Consultation Response KC Waste Strategy
2021/91914 rear of, 28, Northorpe Lane, Northorpe, Mirfield, WF14 0QN
Demolition of one dwelling and the construction of 39 new dwellings with access and associated infrastructure (revised plans).
Date Responded: 16.08.22
Responding Officer: Mike Hibbert
Responding Ref: WPN 21-010A

A consultation response drafted by Carol Oakden dated 04/06/2021 ref WPN21-010 provided comments on superseded plans.

The following comments relate to Drawing P002 Rev Z Dated 27/6/2022

Drawing **Proposed Site Layout**

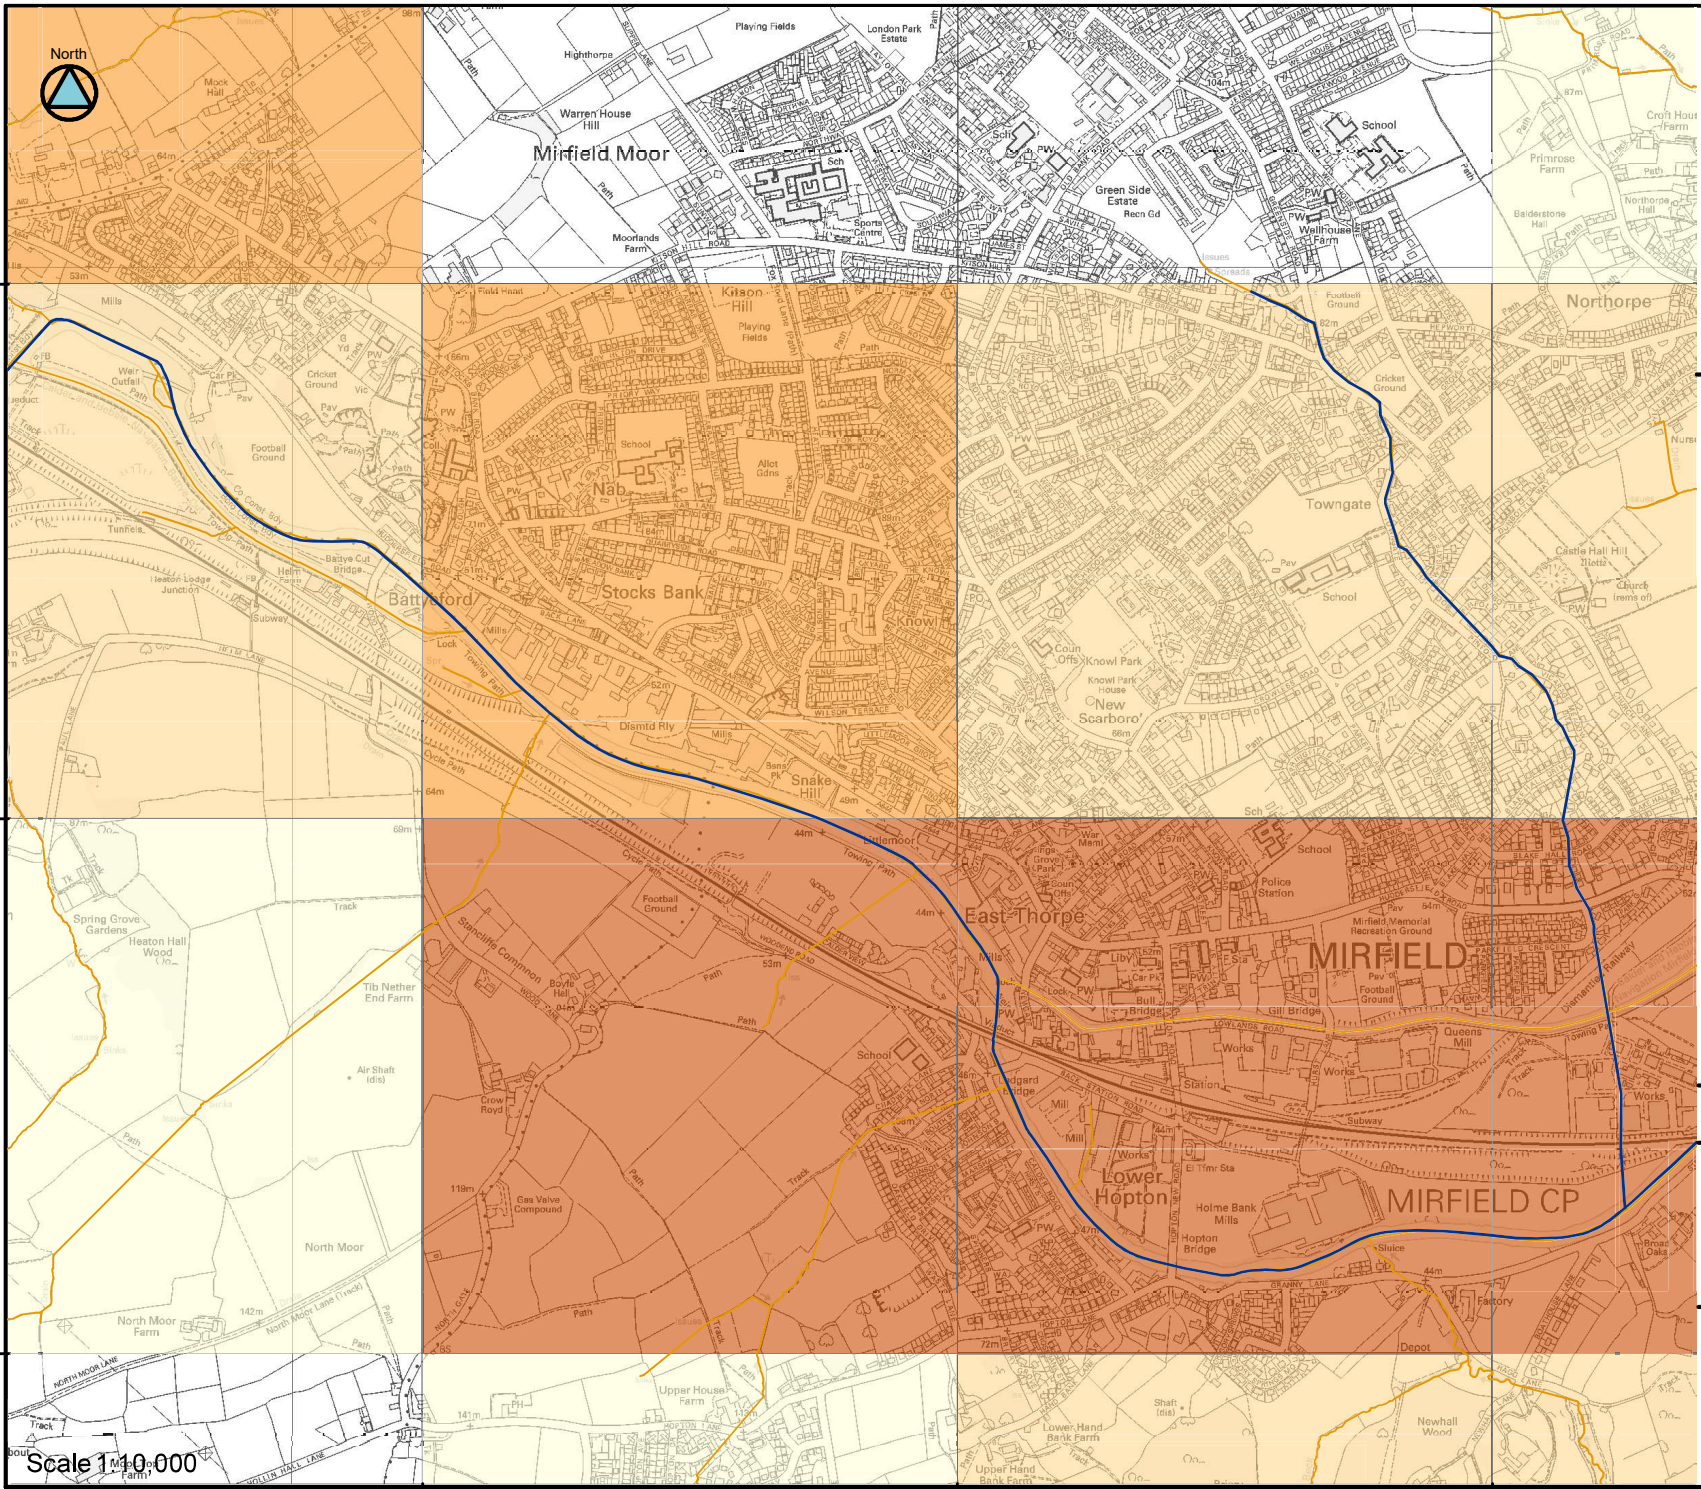
- The drawing indicates the location of bin stores for 3x240 ltrs wheeliebins within the curtilage of individual plots with screening as appropriate for those locations with bin stores at the front of the properties.
- The inclusion of a Bin Collection Point (BCP) for Plots 19 and 20 is welcomed.

- Suitable site access and manoeuvrability space for a large Refuse Collection Vehicle is vital to the Council's ability to discharge its obligation to collect waste from domestic properties. This obligation will exist in perpetuity on any residential development and as such, manoeuvrability must be demonstrated from the outset.
- Consideration must be given to the process of waste collection for properties that are occupied before the whole site is complete. Temporary measures may be required to allow waste to be stored/presented at an accessible location adjacent to the nearest adopted highway. The Authority will not enter construction sites for the purpose of domestic waste collection. Therefore, the following condition is recommended to cover this:
